Planning Application - 20/01122/F “Material Change of Use of land to use as a residential caravan site for 12no gypsy/traveller families, each with two caravans, including improvement of access, laying of hardstanding and installation of package sewage treatment plant”

I am writing to object to this application.

# Proposed Block Plan

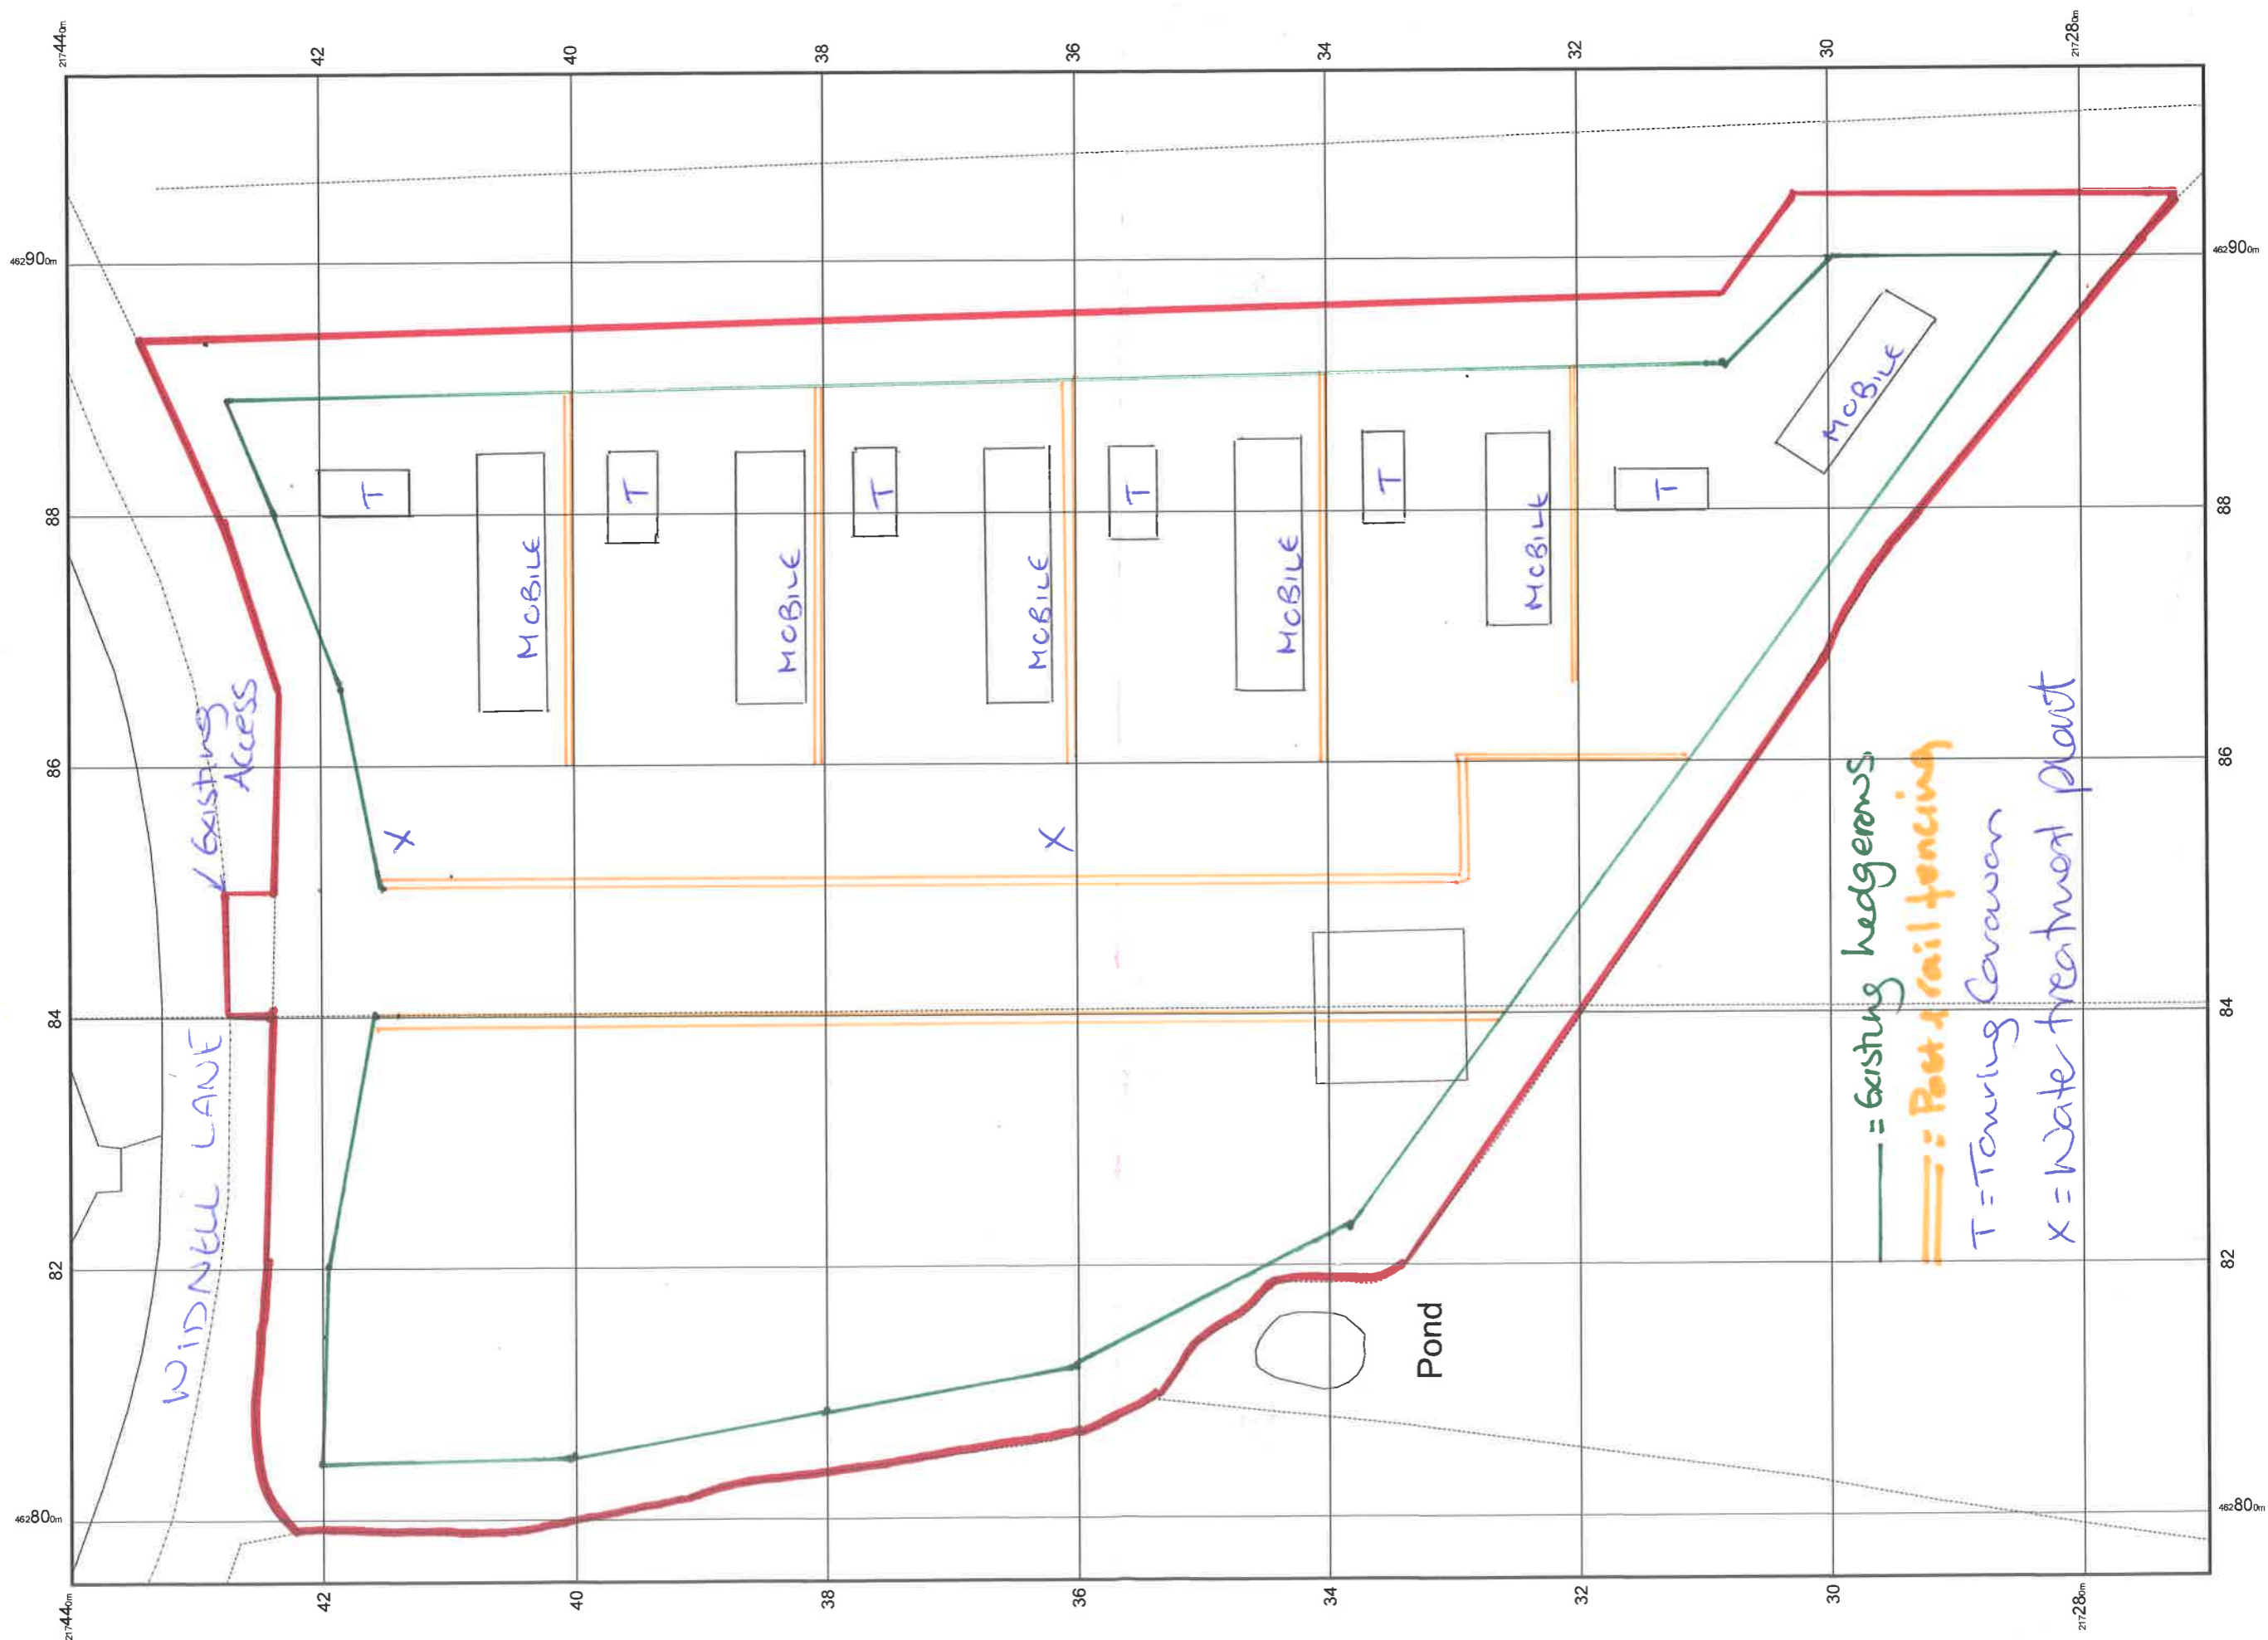
In view of the nature of this application, it should be considered by the Planning Committee and not delegated to a Planning Officer. If approved, then all the conditions imposed by the Planning Inspector should be imposed on the new approval. In addition, the package treatment plant proposed is capable of accommodating a population of 50, which doesn't seem adequate for 12 pitches.
